**Planning Department  
Transportation Development Services**

**Re: Bella Vista Assisted Living  
13101 Constitution NE  
Traffic Circulation Layout**  
Engineer's/Architect's Stamp dated 5-12-15 (J22-D067)

Based upon the information provided in your submittal received 5-13-15, the above referenced plan cannot be approved for Building Permit until the following comments are addressed:

CA-1.0

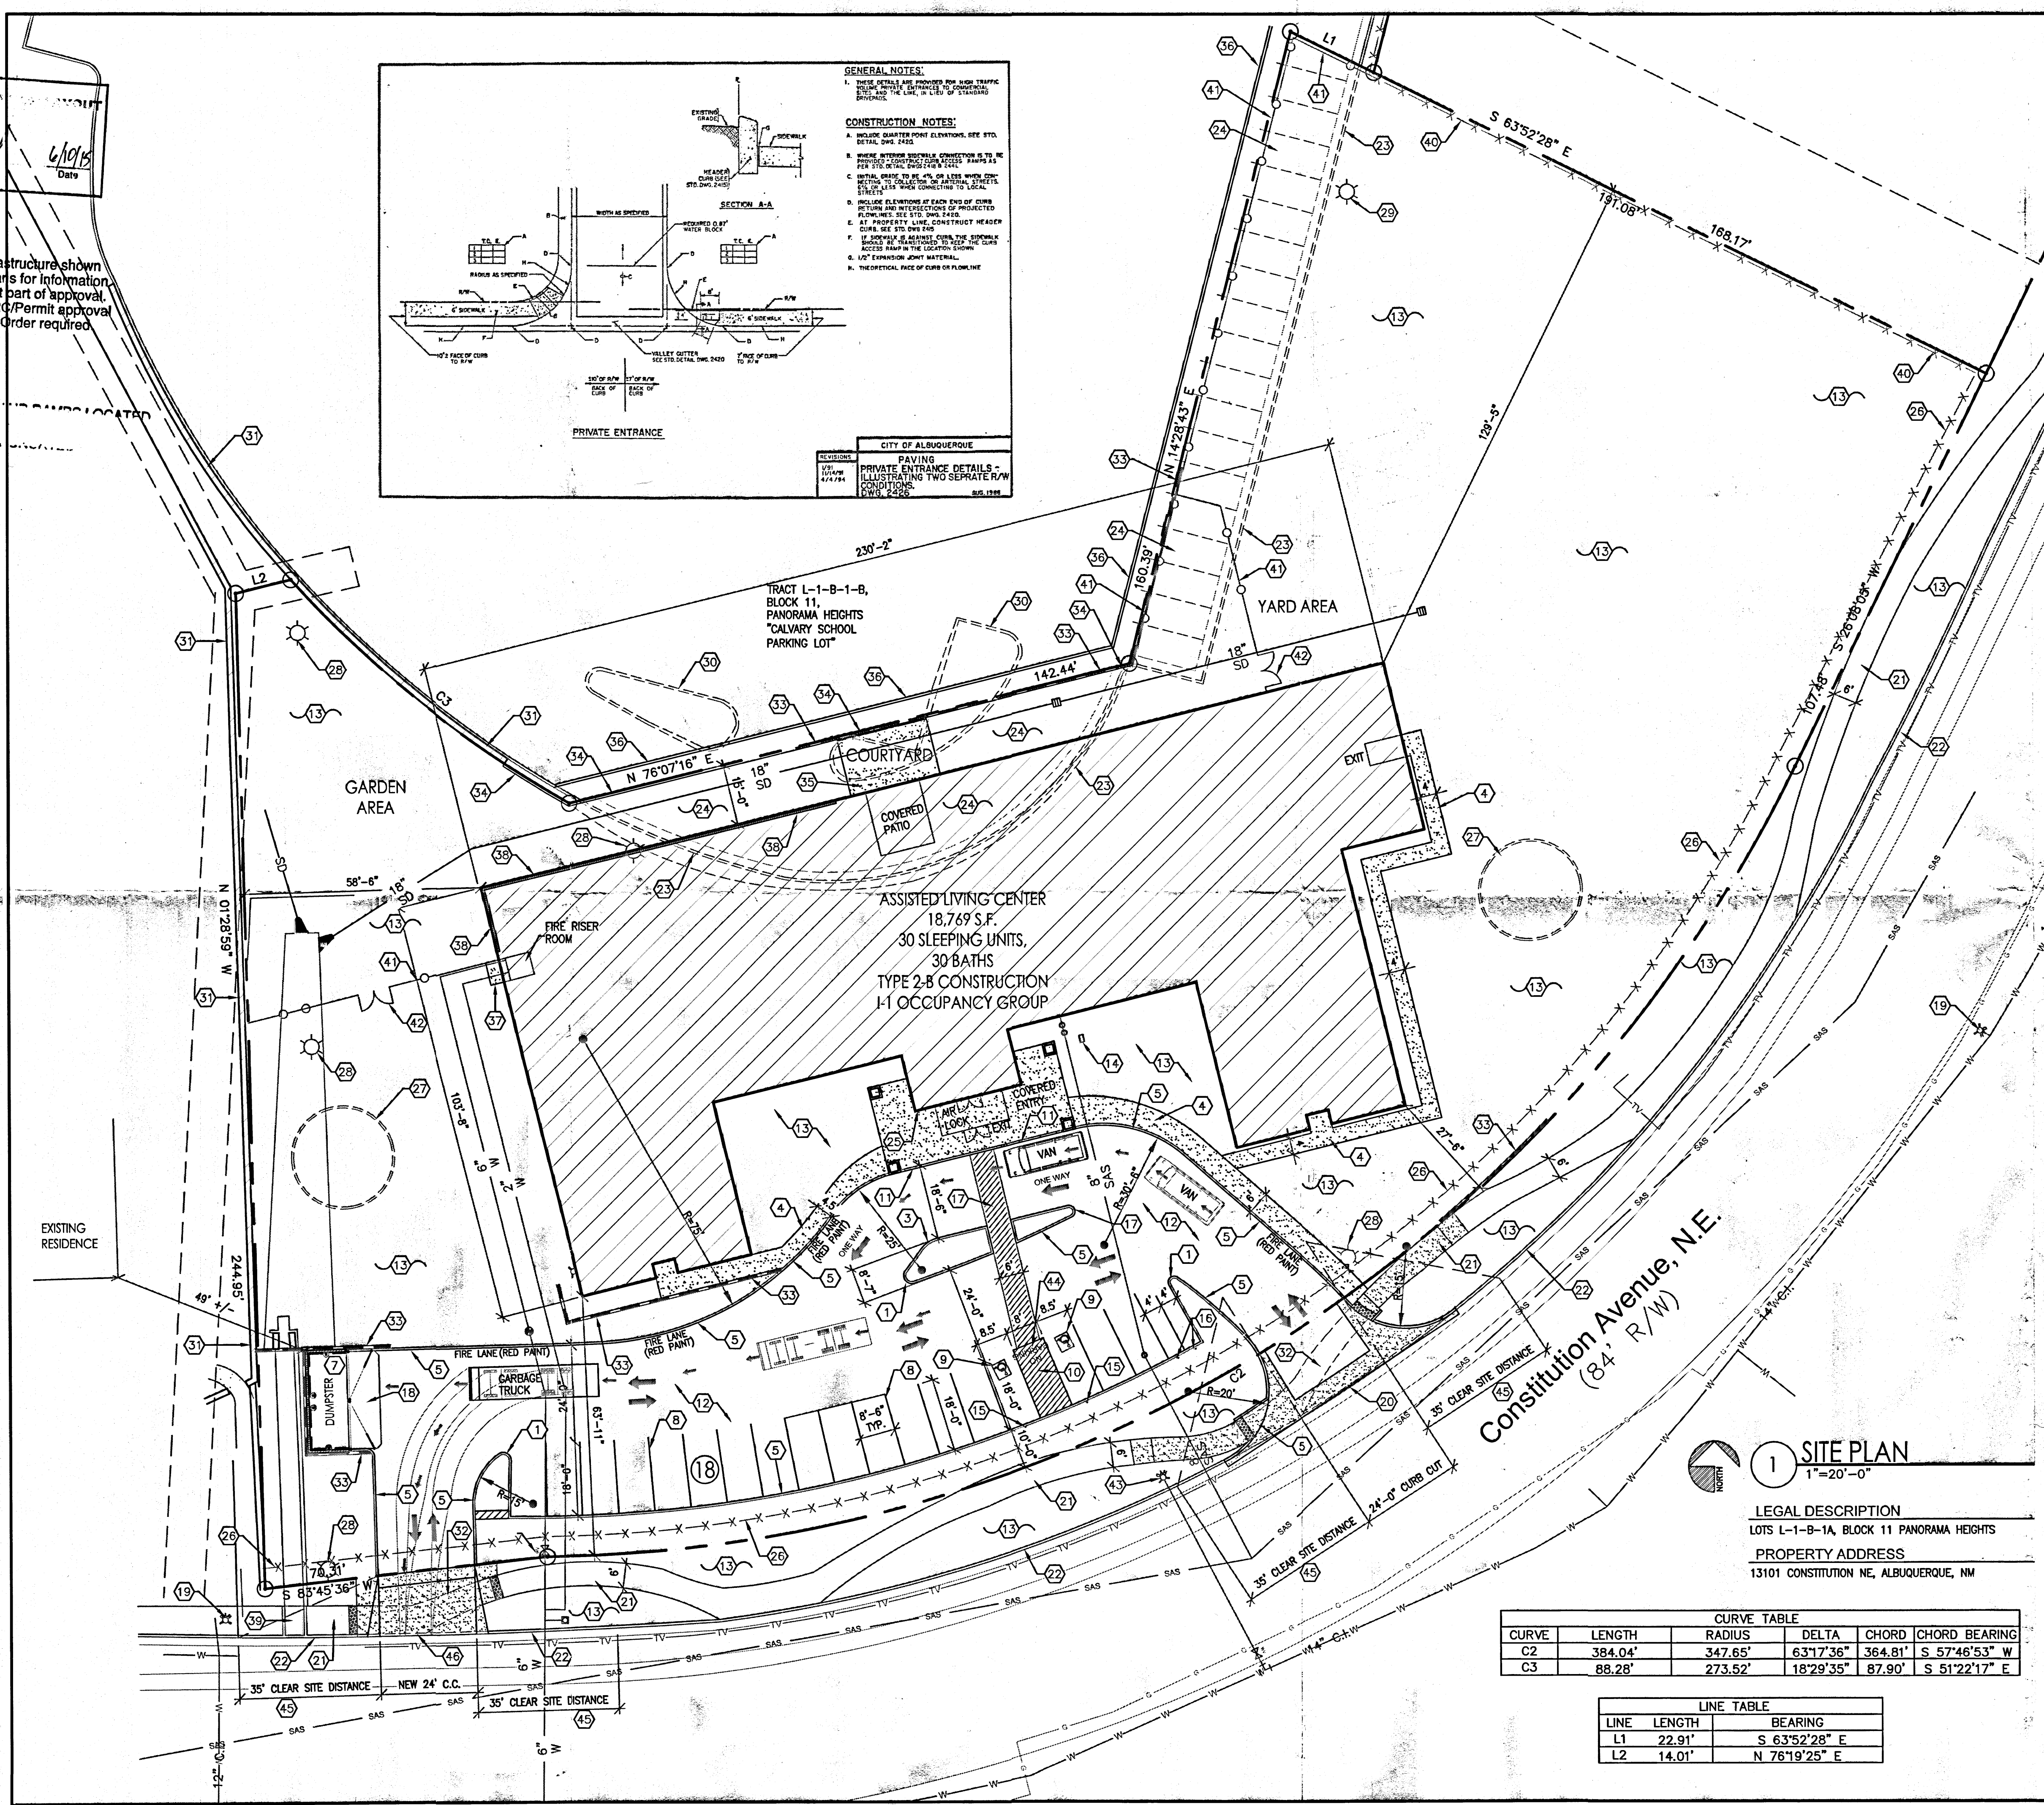
2. The ADA van accessible sign must have the required language per 66-7-352.4C NMSA 1978 **"Violators Are Subject to a Fine and/or Towing."**
3. The ADA access aisle shall have the words **"NO PARKING"** in capital letters, each of which shall be at least one foot high and at least two inches wide, placed at the rear of the parking space so as to be close to where an adjacent vehicle's rear tire would be placed. (66-1-4.1.B NMSA 1978)

4. Per the DPM, a 6 ft. wide ADA accessible pedestrian pathway is required from the public sidewalk to the building entrances. Please clearly show this pathway and provide details and dimension for sidewalks and crosswalks.

5. Per the DPM, a 6 ft. wide ADA accessible pedestrian pathway is required from the HC parking stall access aisles to the building entrances. Please identify and dimension pedestrian pathway to all entrances and exits, also for sidewalks and crosswalks.

6. Design delivery vehicle route needs to be shown.
7. Service vehicle and/or refuse vehicle maneuvering must be contained on-site; provide a copy of refuse approval (if applicable).

8. Please provide a sight distance exhibit for each entryway off of Constitution Ave. (see the *Development Process Manual, Chapter 23, Section 3, Part D.5 Intersection Sight Distance*).

9. Please add the following note to the clear sight triangle: "Landscaping and signage will not interfere with clear sight requirements. Therefore, signs, walls, trees, and shrubbery between 3 and 8 feet tall (as measured from the gutter pan) will not be acceptable in this area."
10. Work within the public right of way requires a work order with DRC approved plans.
11. Label red paint for curb along fire lane.
12. Show doorways to proposed new building.
13. Call out COA standard drawing numbers applicable for work done within COA Right-Of-Way including COA Standard Drawing 2425 for drive pads and 2426 for private entrances.
14. Provide curb ramps for private entrance on the east side of proposed building and provide detail of curb ramp, include detectable warning surface.
15. Please include two copies of the traffic circulation layout at the next submittal.
